**From:** kazys [REDACTED]  
**Sent:** 25 July 2019 13:50  
**To:** Laura Gibbons <Laura.Gibbons@arun.gov.uk>  
**Cc:** Edward Rees [REDACTED] Zac Denton <Zac.Denton@arun.gov.uk>; Kerry Simmons [REDACTED]  
**Subject:** RE: Mistletoe Farm, Horsemere Green Lane. CM/13/19/RES; Revised Drainage Proposals

**From:** kazys <[REDACTED]>  
**Sent:** 17 July 2019 09:54  
**To:** Laura Gibbons <[Laura.Gibbons@arun.gov.uk](mailto:Laura.Gibbons@arun.gov.uk)>  
**Cc:** Edward Rees <[REDACTED]>; Zac Denton <[Zac.Denton@arun.gov.uk](mailto:Zac.Denton@arun.gov.uk)>  
**Subject:** Mistletoe Farm, Horsemere Green Lane. CM/13/19/RES; Revised Drainage Proposals

Tree Retention & Protection Plan

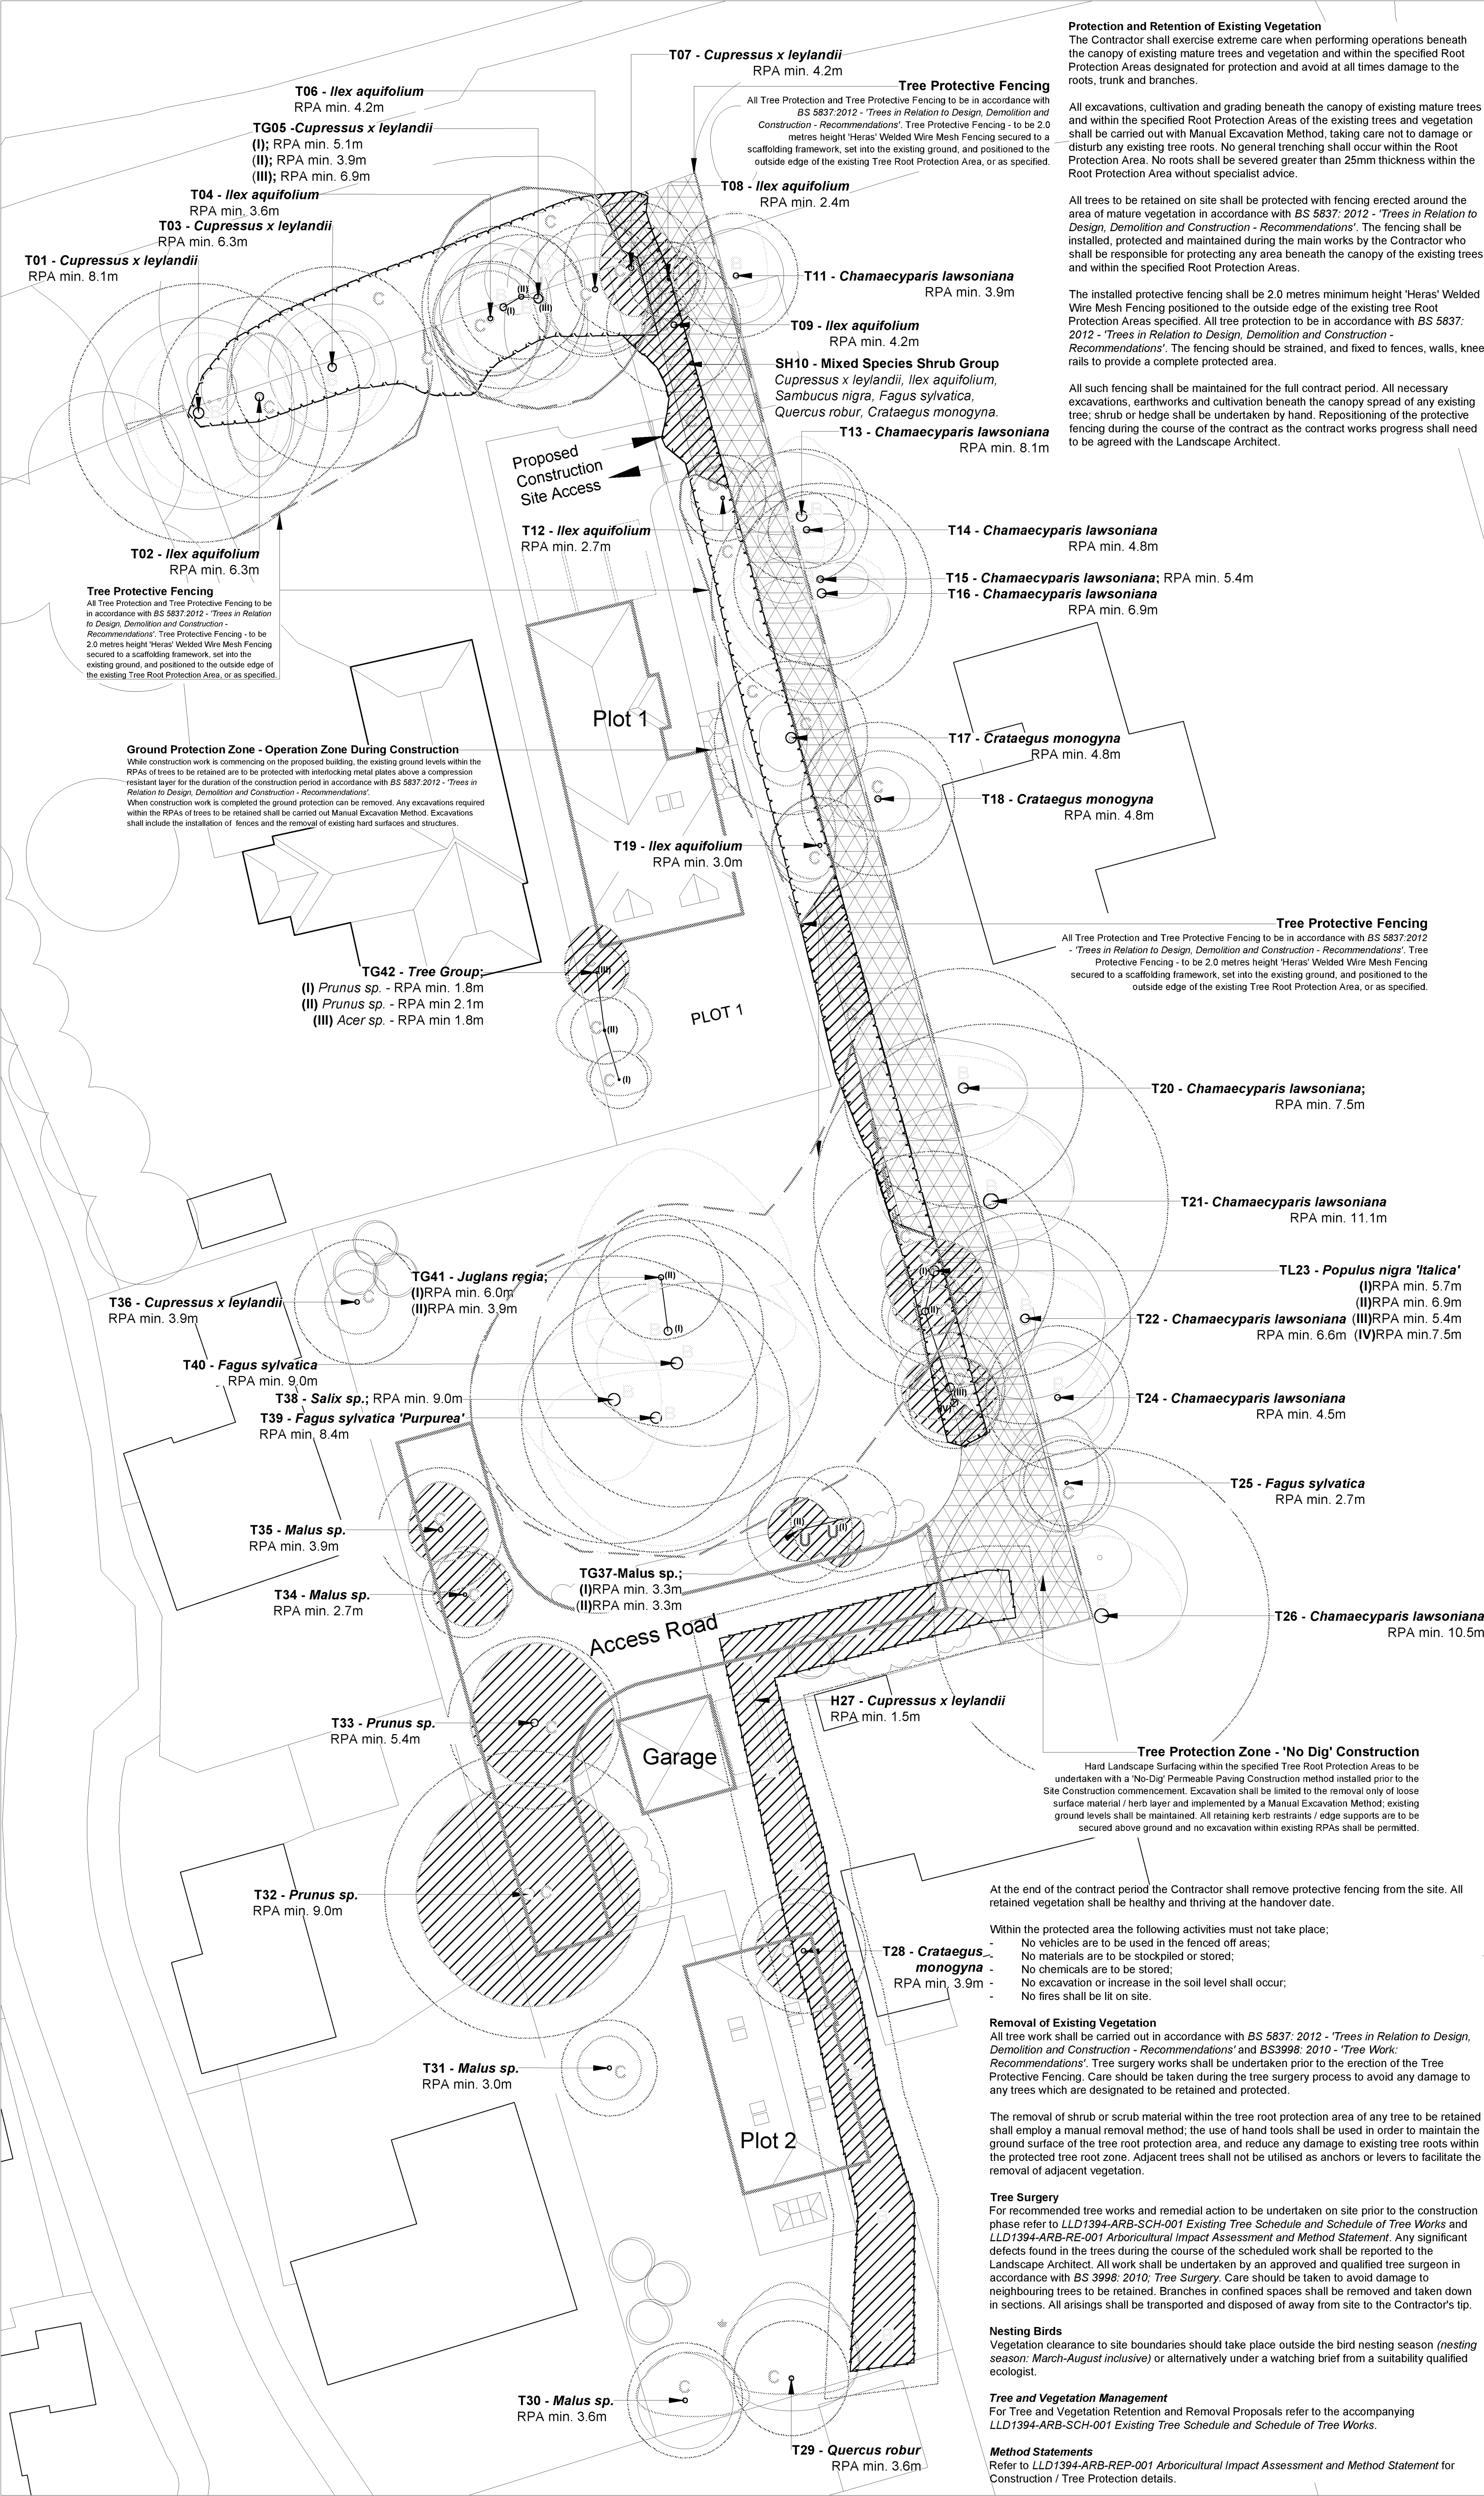
I have now received feedback from our tree officer, to quote his summary "I find the proposed location for the swale to be wholly unacceptable and would expect the applicant/agent to provide an alternative scheme that meets with your requirements and fully respects T38 – T41 incl. or consider an alternative site layout." His full response is attached.

I wonder if the swale could be located outside of the RPAs. Could you look at extending the permeable paving further north and forming the outlet to the swale here, and maybe sweeping round to the downstream pipe connection?

Thank you for sending over the revised plan. I believe there is some conflict between what you are proposing and the tree protection plan (attached).

The permeable paving for plot 2 looks like it could only be located in the T furthest round on the road rather than at the junction of roads 1 and 2. The swale also appears to be within a no dig area.

I have produced an amended strategy (taken a little longer than originally anticipated)  
which hopefully will meet with your approval and satisfies your tree officers requirements.

Thank you for your comments. I was under a misapprehension regarding the RPZ so having cleared that I have put together a revised proposal which addresses your comments on the RPZ. Hopefully you find this revised proposal accords with your thoughts and you are able to advise your planning colleague that we have reached a drainage solution. As always, if you have any further concerns please contact me. Many thanks.
